Re: Desert Sands Subdivision Preliminary Plat, DRB# 1005224

Attached please find a revised Infrastructure List, Preliminary Plat, Grading Plan, and Sidewalk Exhibit incorporating revisions to address the comments received at DRB on Feb 17, 2016. The comments have been addressed as described below in red.

CITY PROJECT NO.	ZONE MAP NO.	SHEET	OF
		3	5

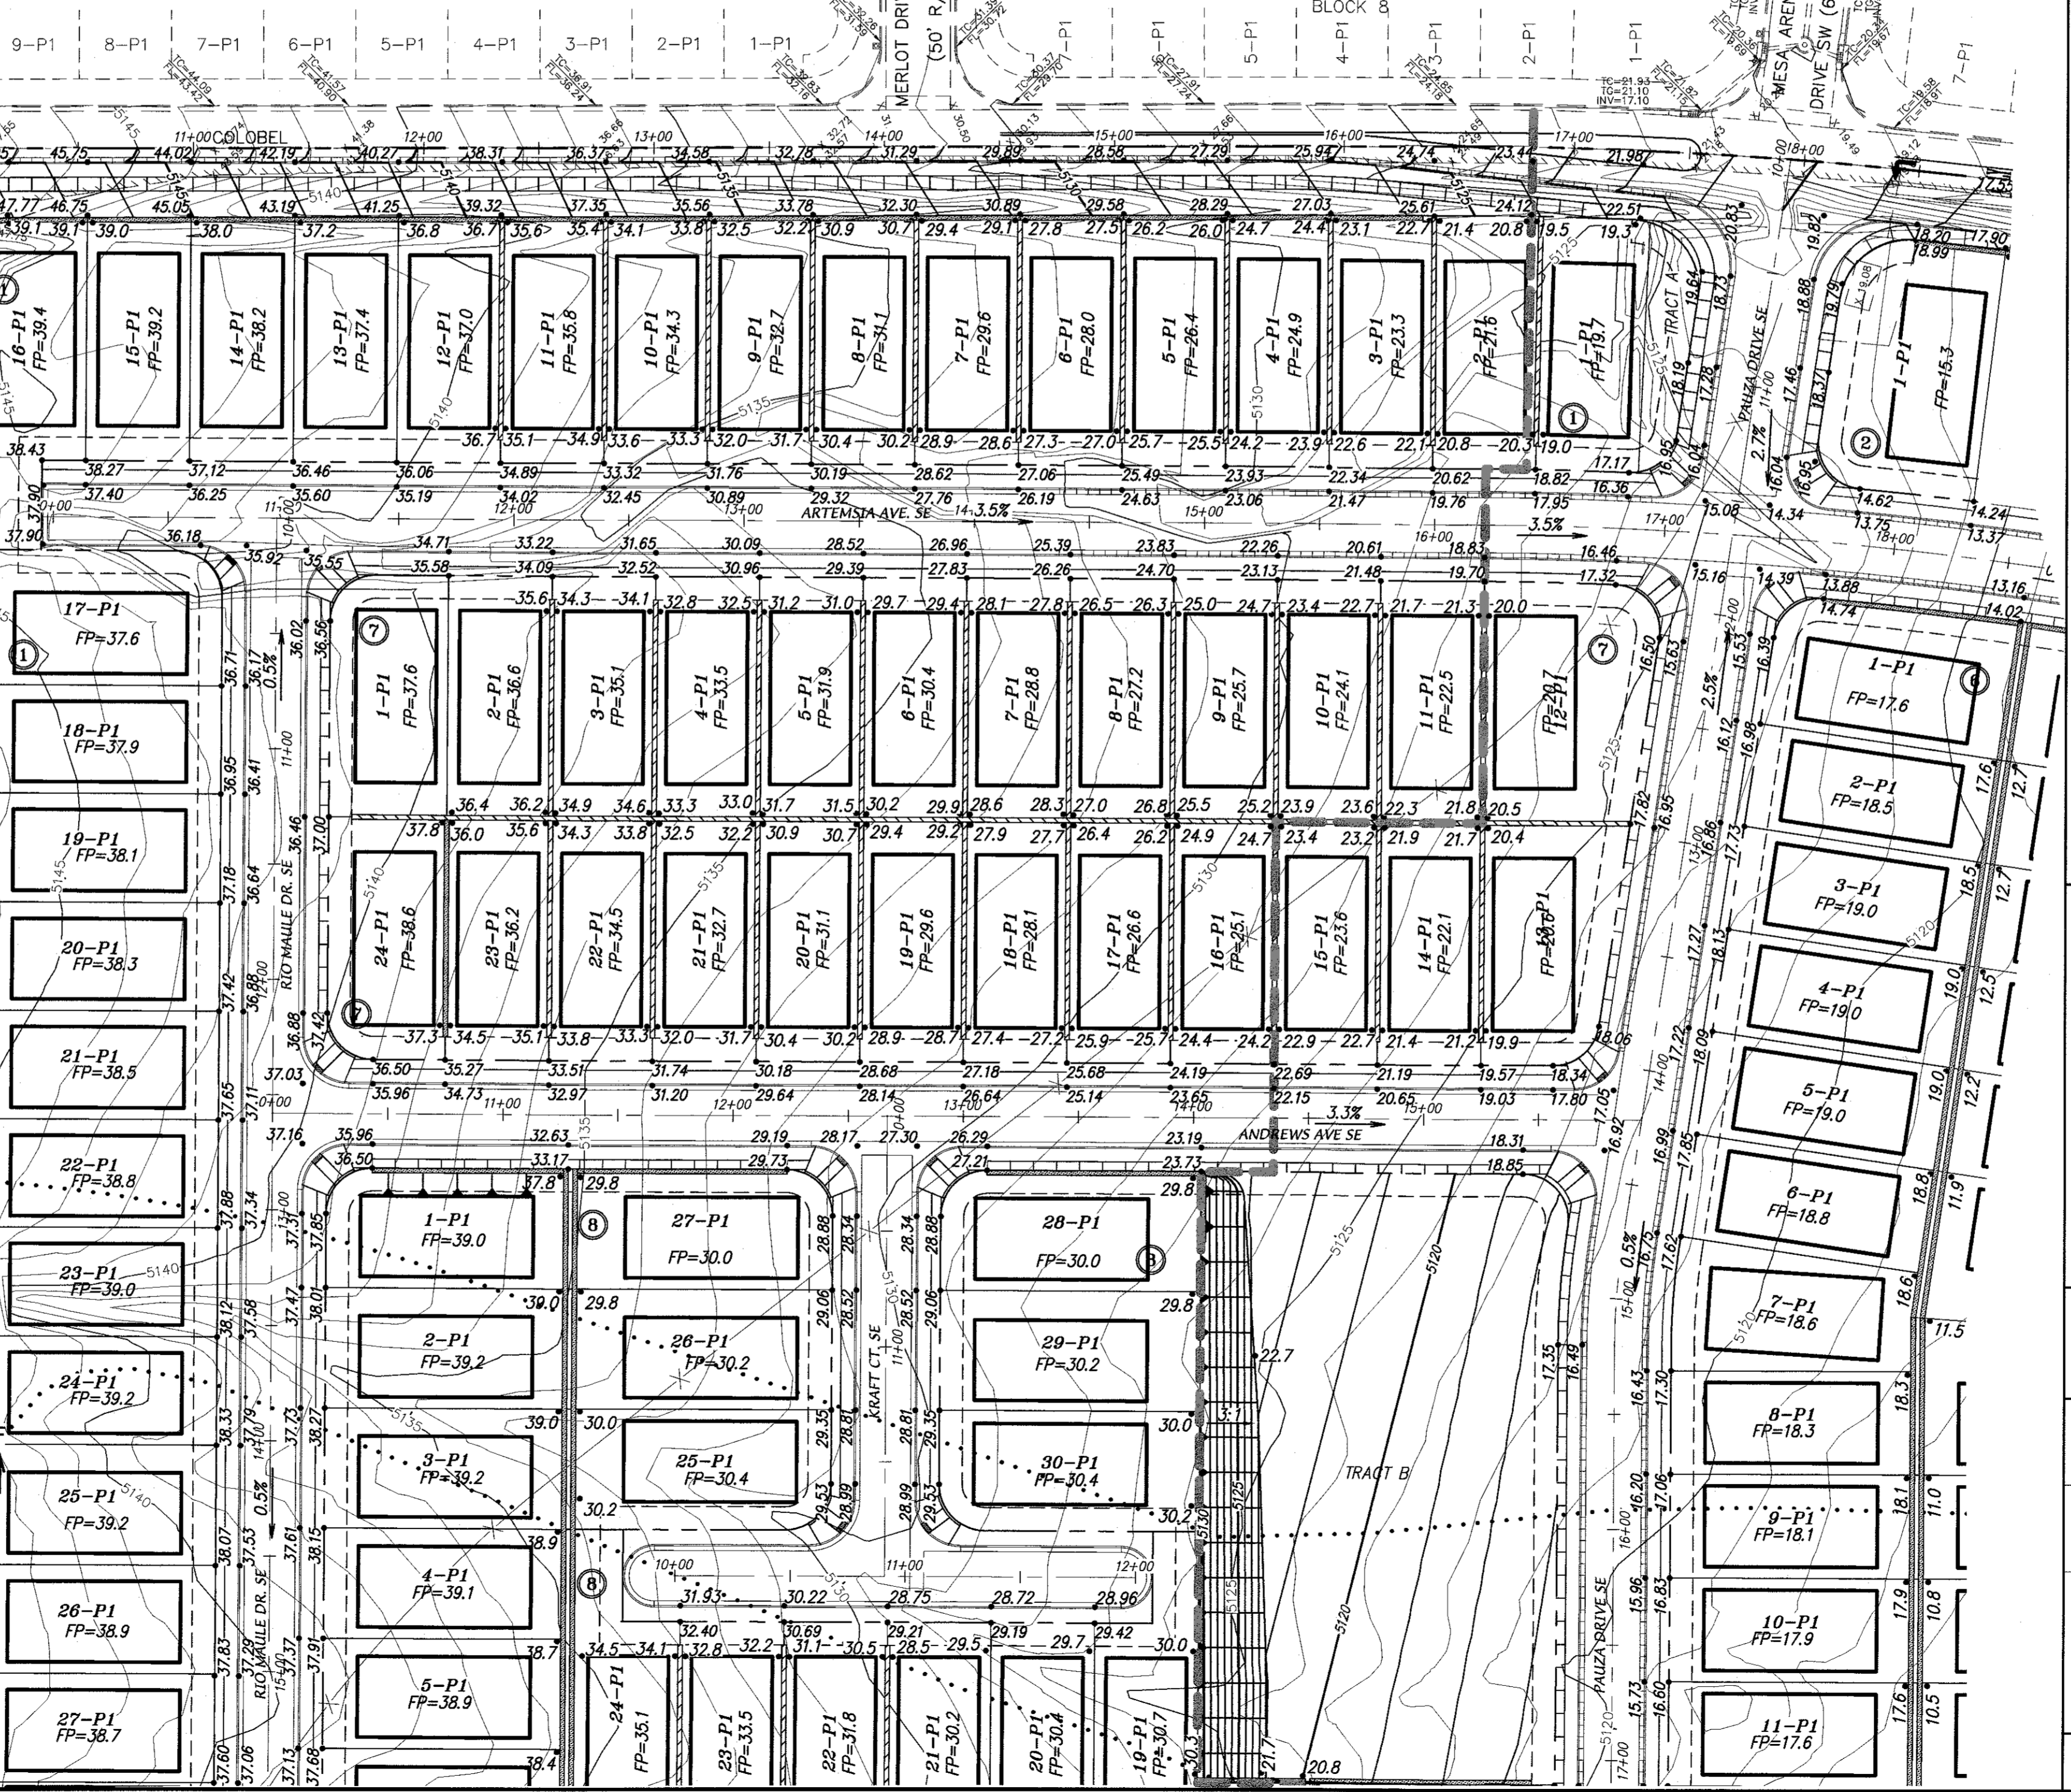
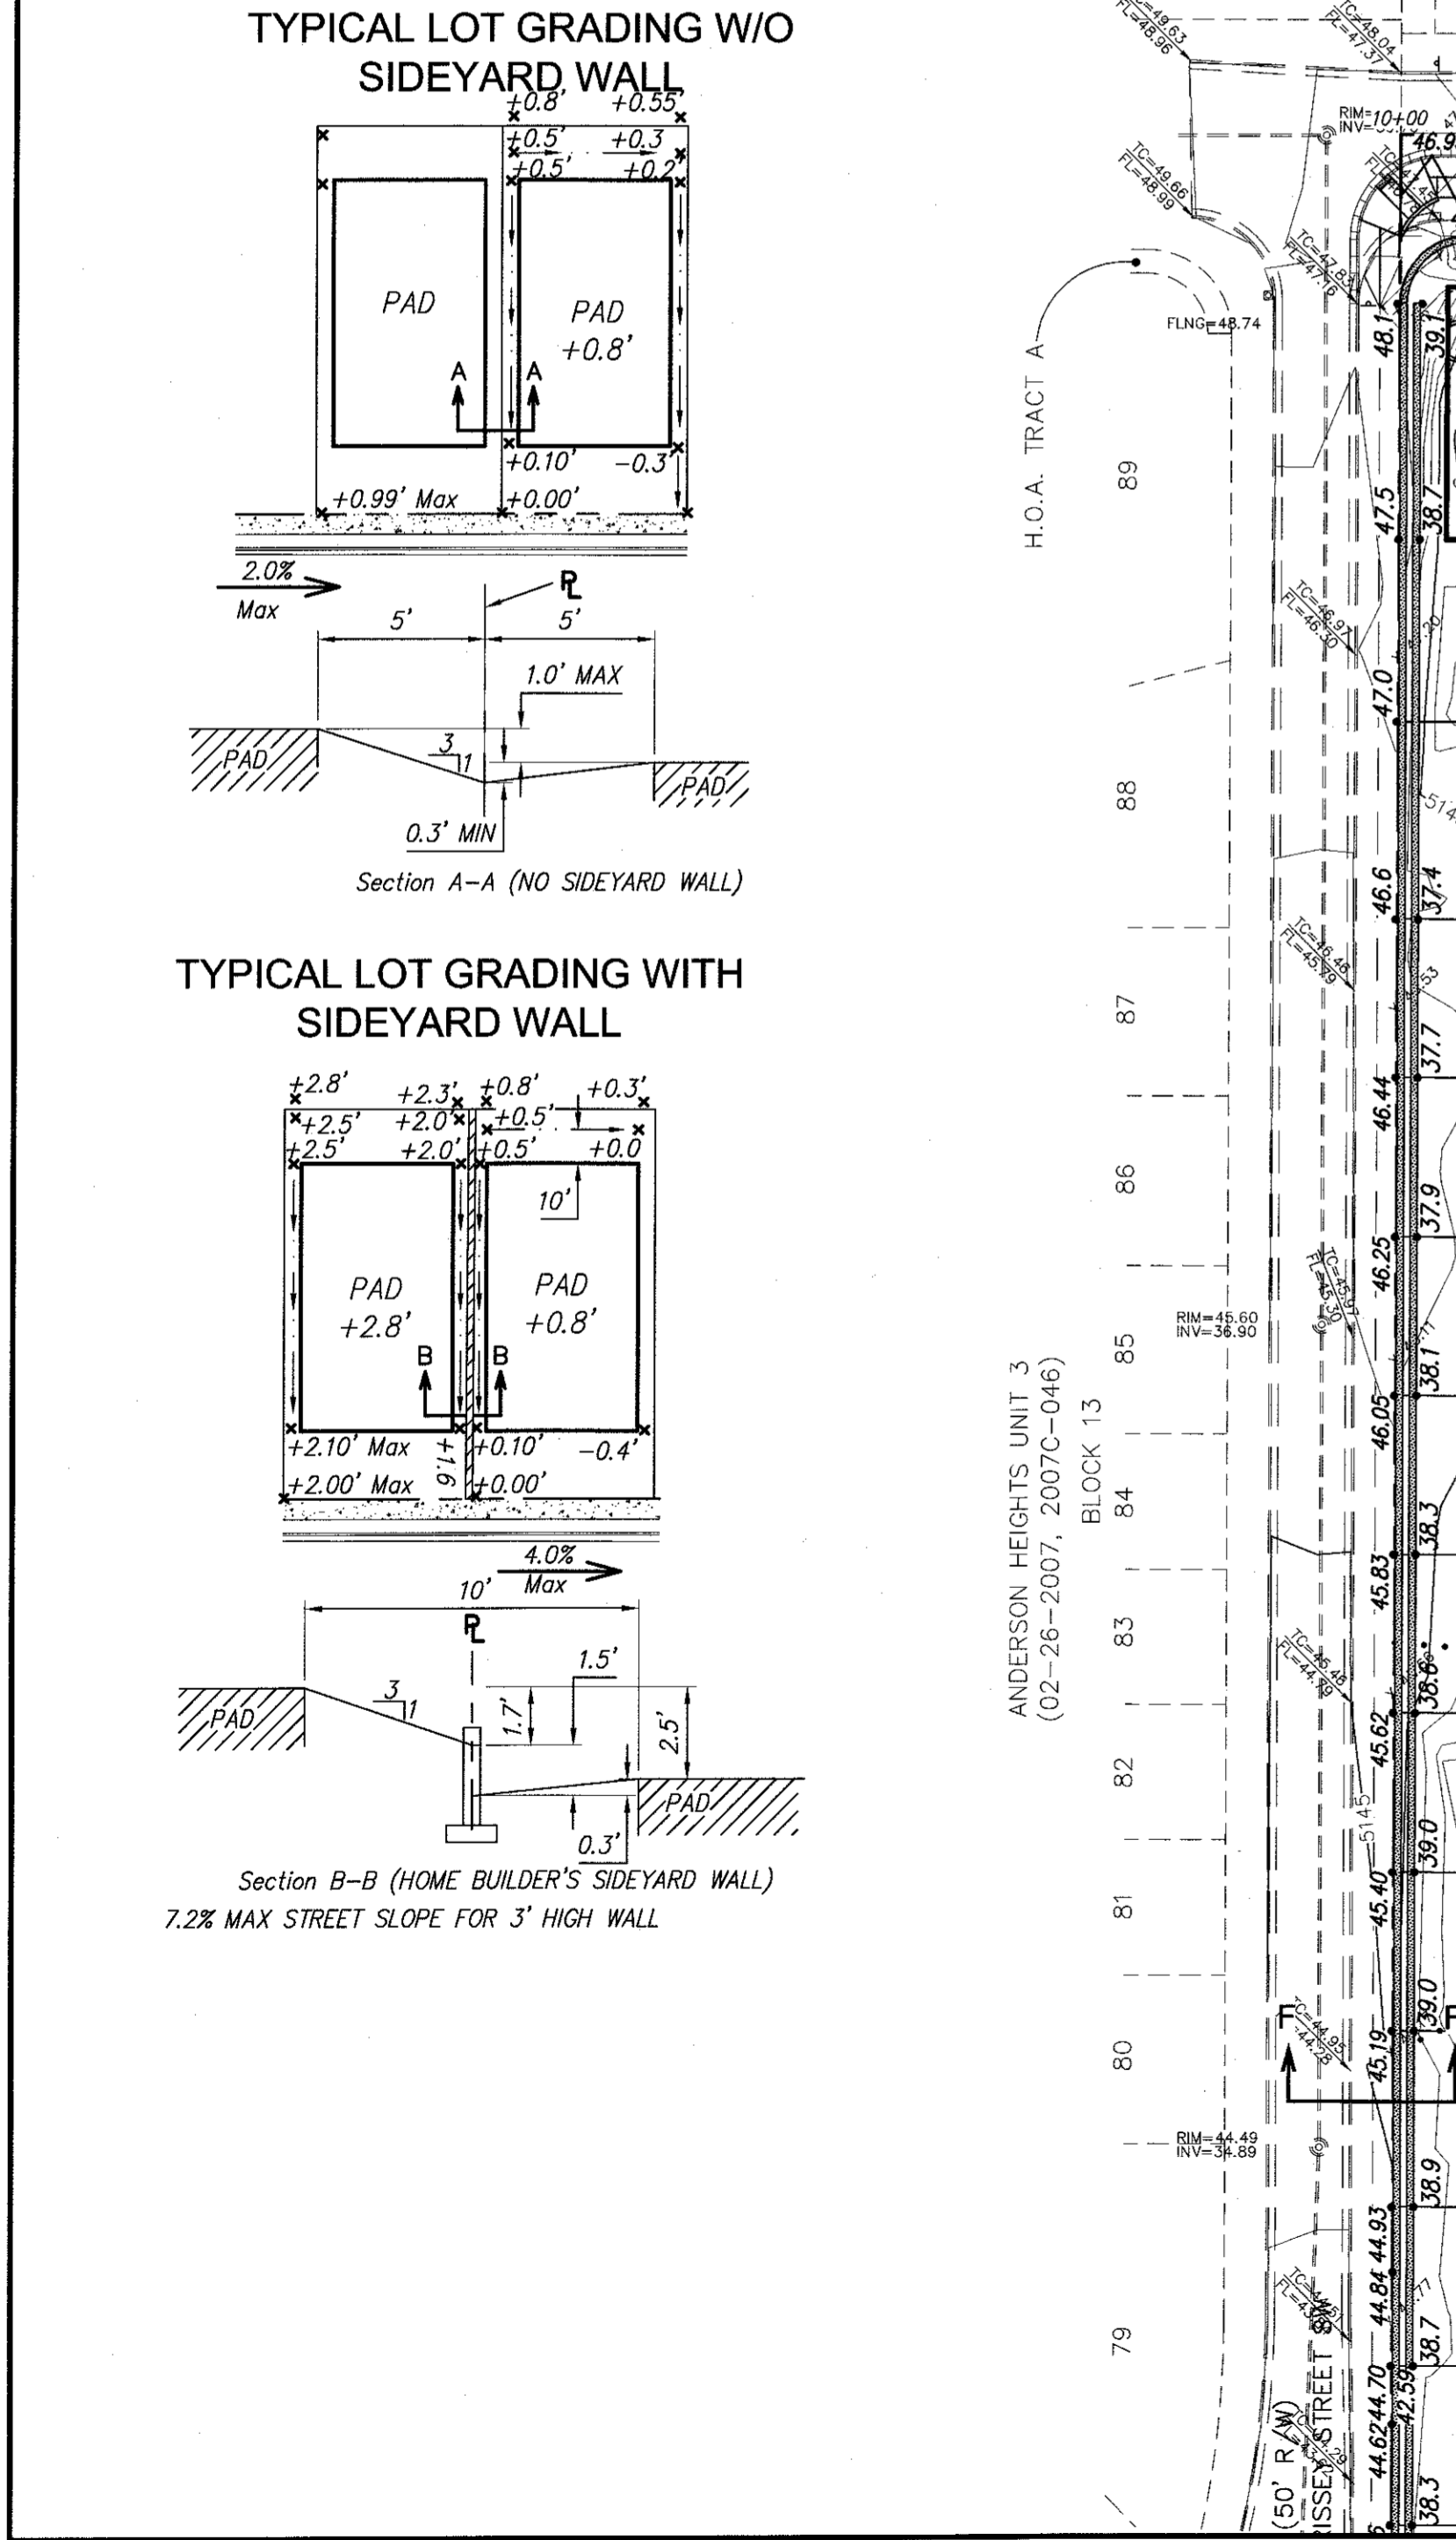
- 1) *Preliminary Plat, Infrastructure List, Grading Plan, Utility Plan*
 - a) *Pro rata is duly noted.*
 - b) *Service Requirements*
 - i) *The Grading Plan has been revised to lower the elevation of the lots on the west side of the project so that none of the pad elevations are above the 2WR elevation of 5140 (NAVD 27/29).*

Additional pedestrian connections have been added to sheets 1,2,and 4 of the Grading and Drainage Plan and to pages 3 and 6 of the Infrastructure list. Pedestrian easements have been added on the Preliminary Plat.
